Detailed Comments

BURNSIDE DRIVE FOOTPATH AND ROAD WIDENING

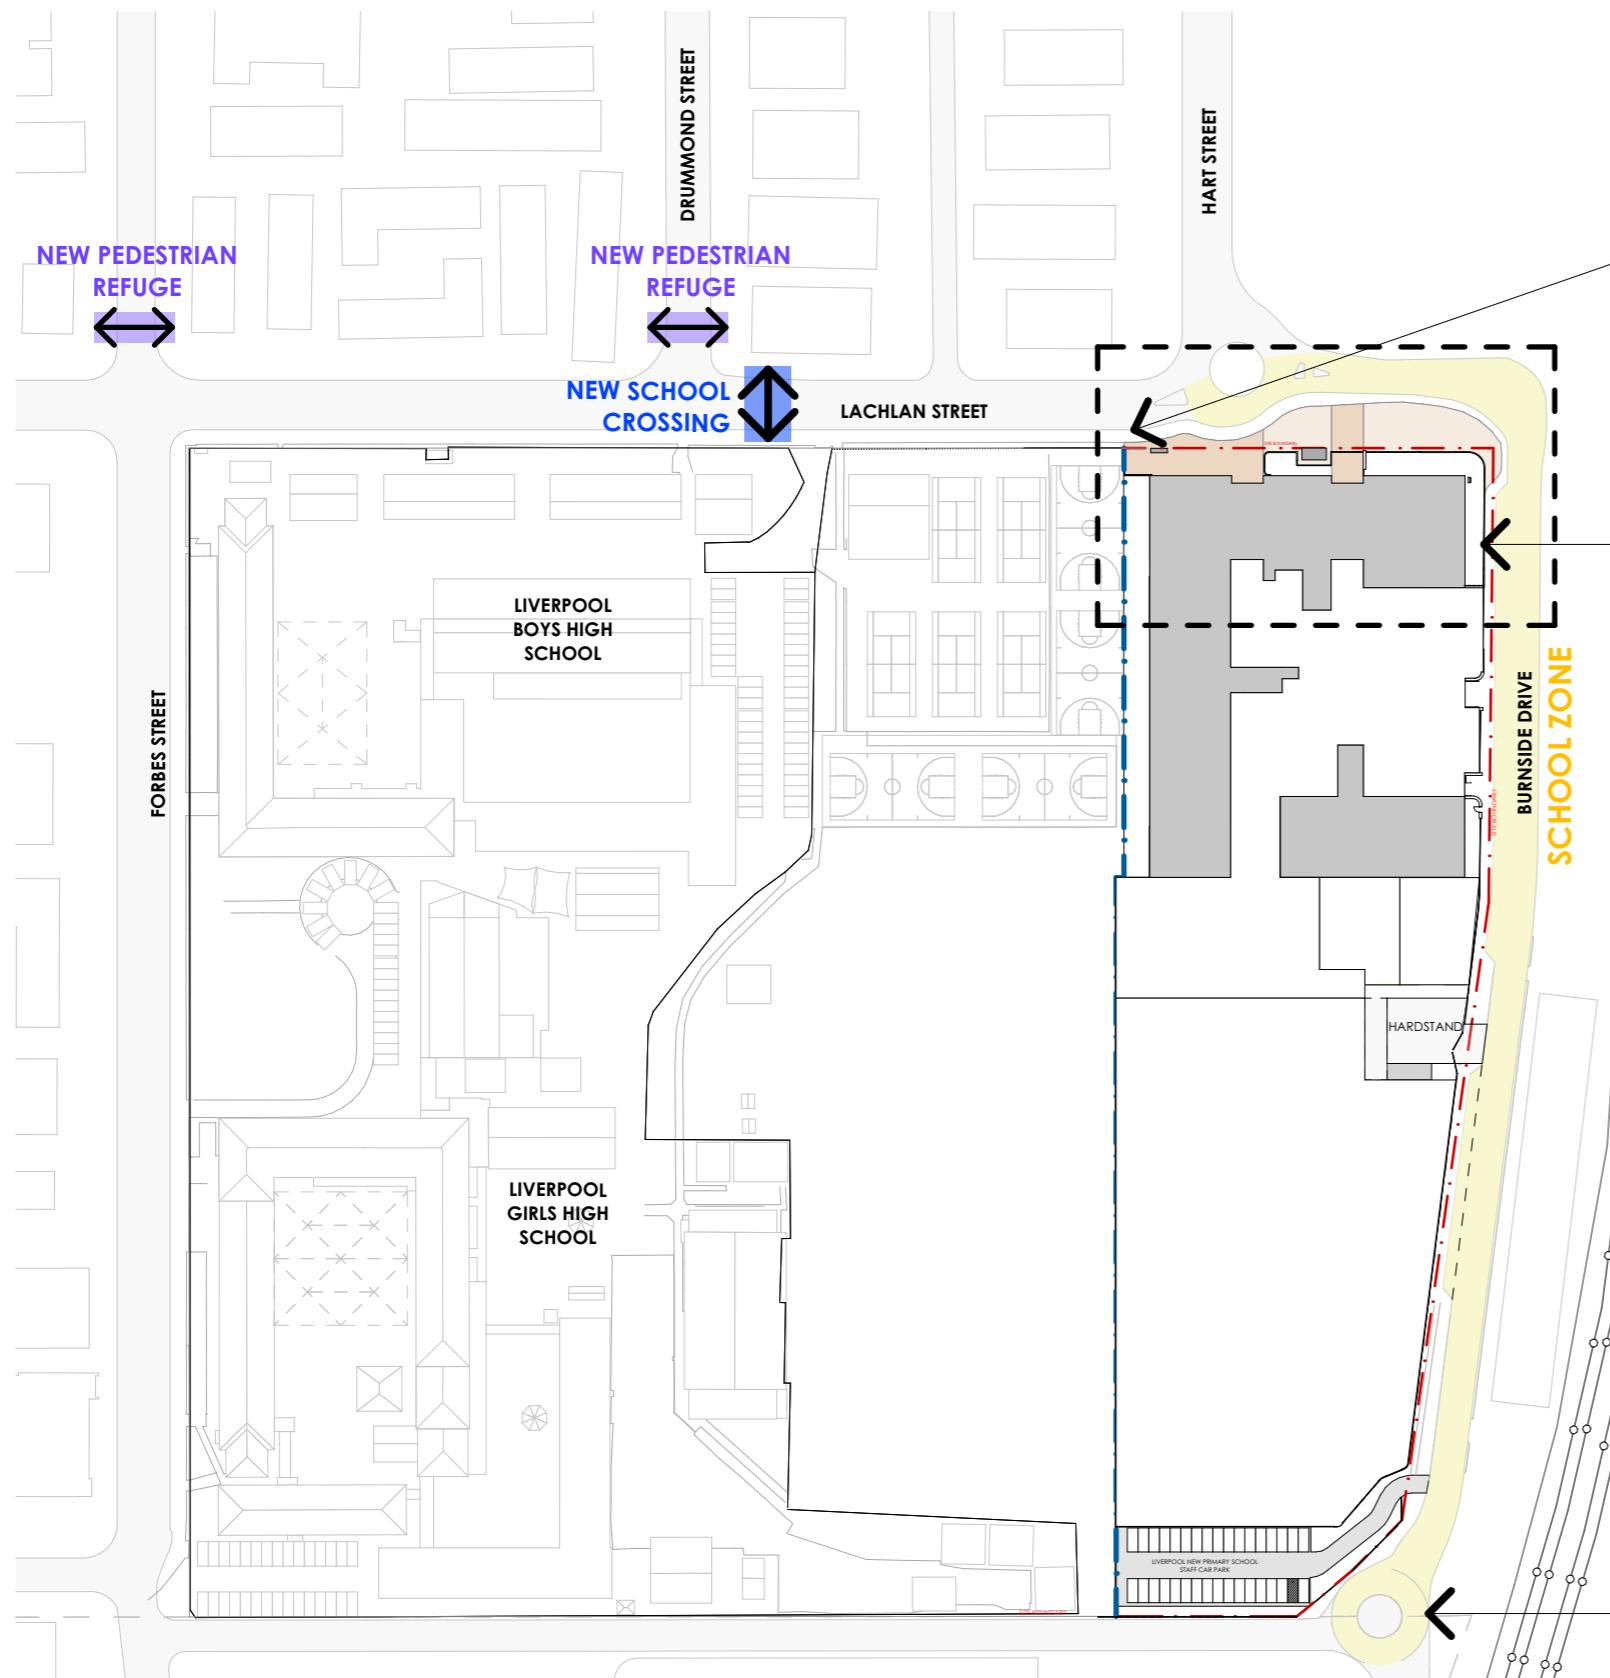
The allocation of a pedestrian refuge outside the school will be inadequate, as this will be a high traffic route to the hospital's new multistorey car park. We recommend a priority wombat crossing directly outside the school on Lachlan Street to support pedestrians moving between Warwick Farm train station, the school precinct and Liverpool Hospital further south.

For all vehicle entry points to the school and along Lachlan Street, we recommend that priority is given to people walking via continuous footpaths to ensure those in wheelchairs, prams and with disabilities have seamless access to footpaths.

NEW ROUNDABOUT

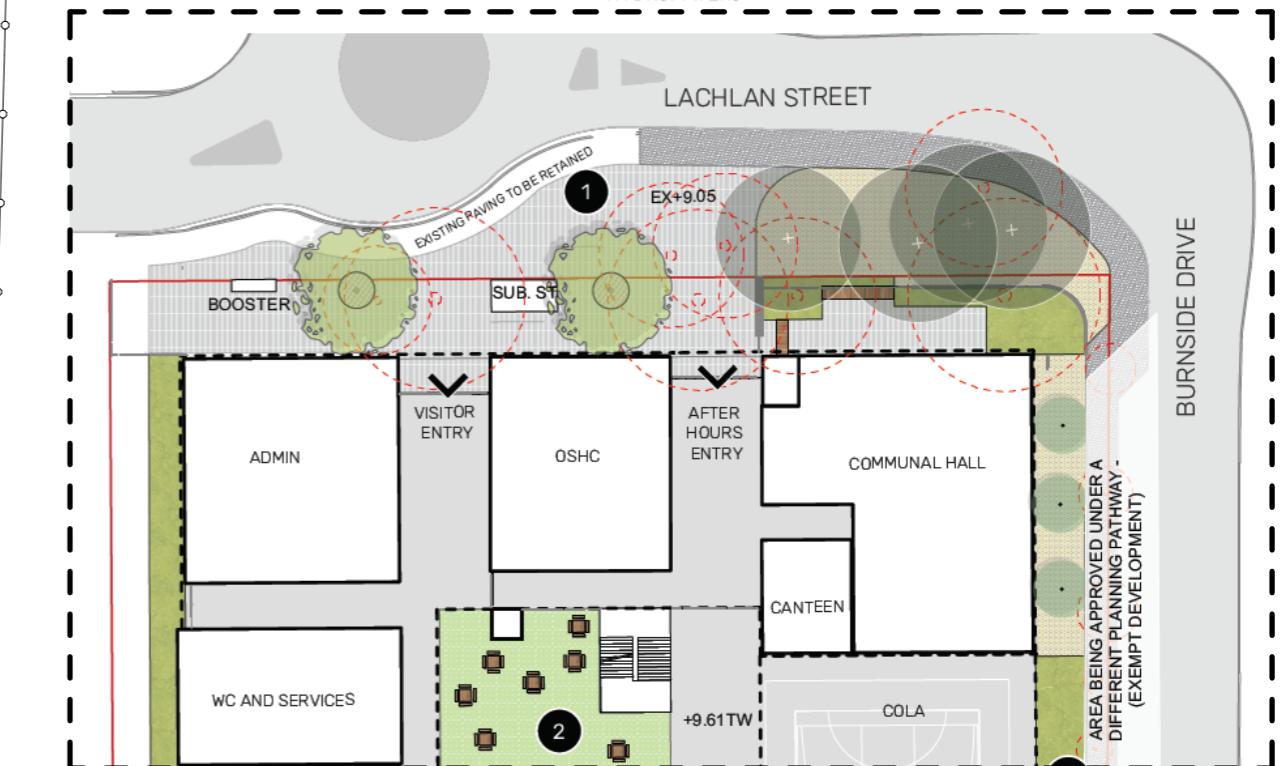
The location of the roundabout directly outside the NLPS is far from ideal, even with the proposed pedestrian crossings. Roundabouts are not a safe or convenient option for people walking and cycling, and particularly for children, as they are unable to judge vehicle movements and exits at roundabouts. As outlined in Cycling Aspects of Austroads Guides³, studies have also shown that roundabouts increase the risk of crashes for cyclists.

If Hart Street is blocked off at the intersection with Lachlan Street and through traffic is redirected down Drummond Street or Forbes Street, this will remove the need for a roundabout right outside the school. It will also create a safe drop off environment in Hart Street for children to then walk a short distance safely to school. Closure of Hart Street would have ramifications on traffic flows in

The proposal for a bus route down Lachlan Street with turning at the roundabout is unlikely to be beneficial for people walking and cycling. Widening the roundabout and intersection for buses to make u-turns will make it even more difficult for people to cross at intersections and mid-block. The closest bus stop on Goulburn Street is less than 400m from the school. The Warwick Farm train station is also just over 400m walk from the school. There needs to be a greater focus on improving the walking experience (wider footpaths, shade, priority continuous crossings) to these transport stops.
